Application by The Drovers Solar Farm Limited for The Drovers Solar Farm

The Examining Authority's written questions and requests for information (ExQ2): Issued on 2 July 2026

Annex C: Outline Surface Water Attenuation Area

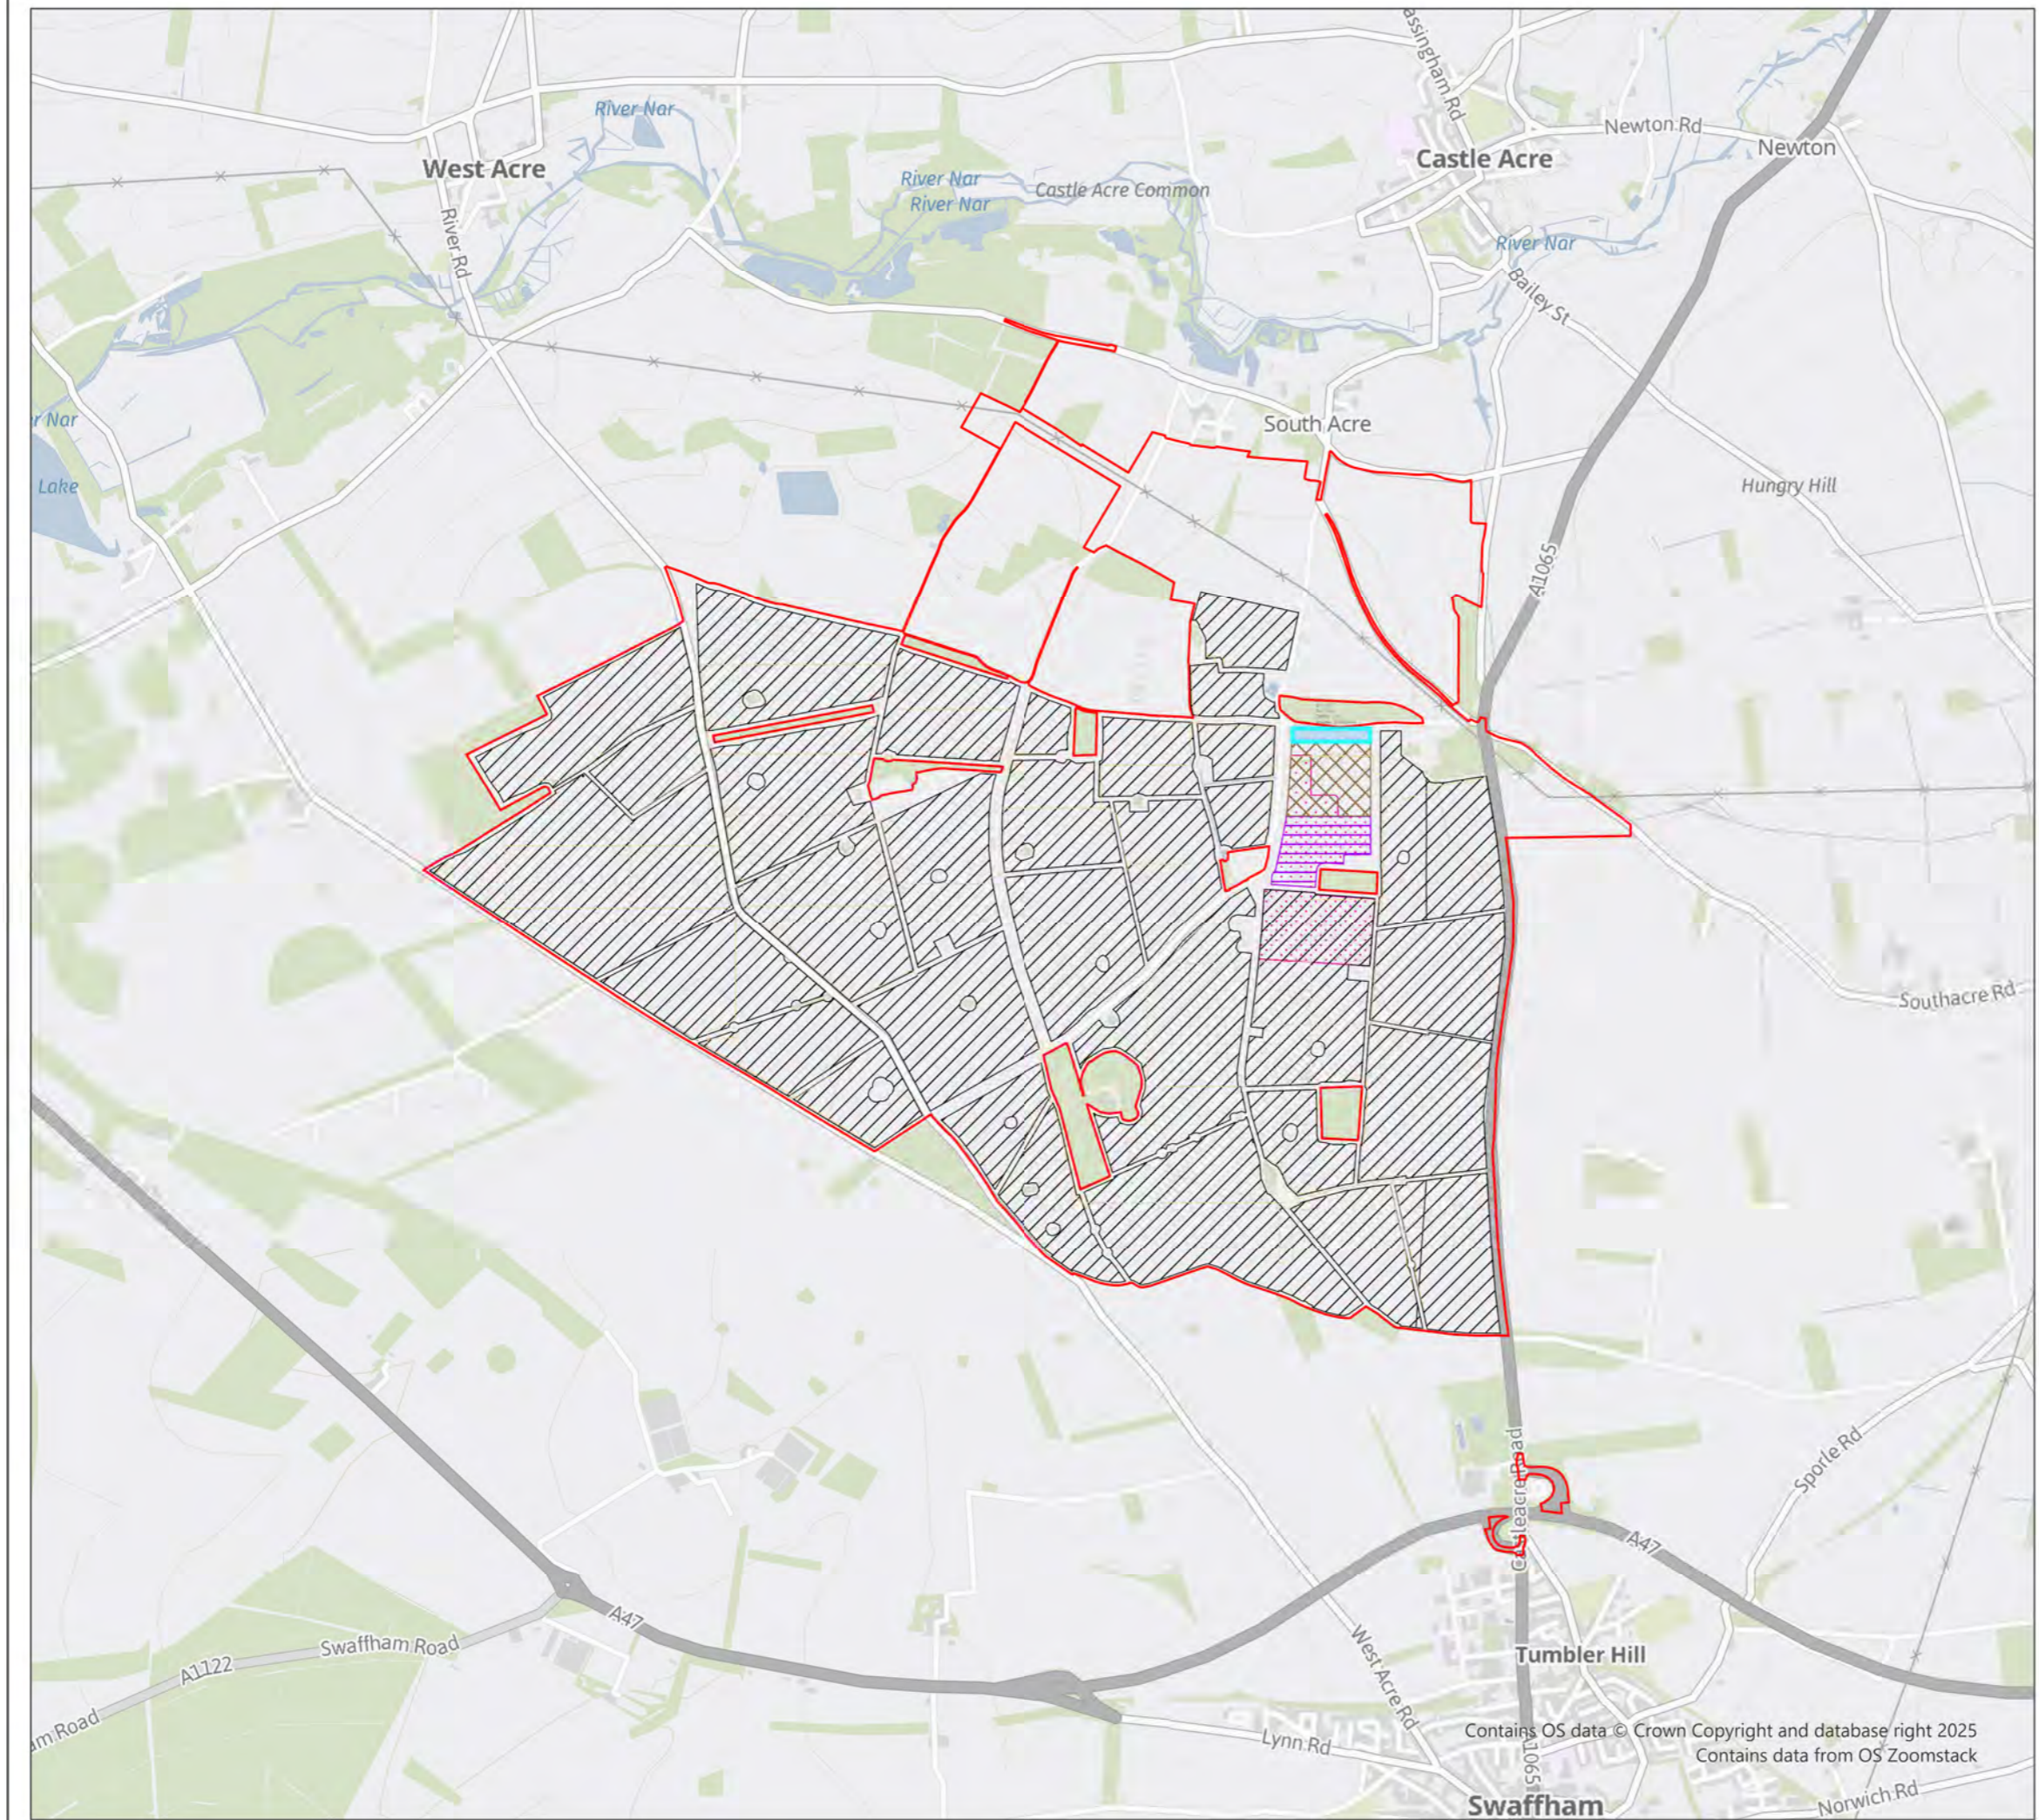
ExQ2	Question to:	Question:
	NCC Response:	A present, the filter drains, drainage ditches and swales are undefined in size. The applicant has undertaken some initial infiltration testing, although this is only in the area of the BESS and Substation platforms. These infiltration tests are not in the approximate locations of the where the access tracks are to be located. The applicant has undertaken preliminary calculations in the FRA for the sizing the attenuation basin that serves the BESS and / or National Grid Substation (although the calculations are not clear on which area is associated to which works). There are no preliminary calculations for a typical arrangement of operational access track. Therefore, it is not possible to determine where infiltration is viable across the whole site or where the alternative discharge location (Plan B) from these features is. The minimum requirements for FRAs are outlined in paragraph 5.8.15 of NPS EN-1, which clearly states that applicants should "Set out (approximately) the existing rates and volumes of surface water run-off generated by the site. Detail the proposals for restricting discharge rates" and "Set out proposals for managing and discharging surface water from the Site using sustainable drainage systems and accounting for the predicted impacts of climate change." At present, the FRA and the proposed works descriptions are not clear on this and therefore, it is difficult for the scheme to include a suitable and consistent provision based upon this information. NCC as the LLFA, requests that some further evidence is provided to demonstrate the viability of the proposed approach as there is a gap in the preliminary design on this matter.
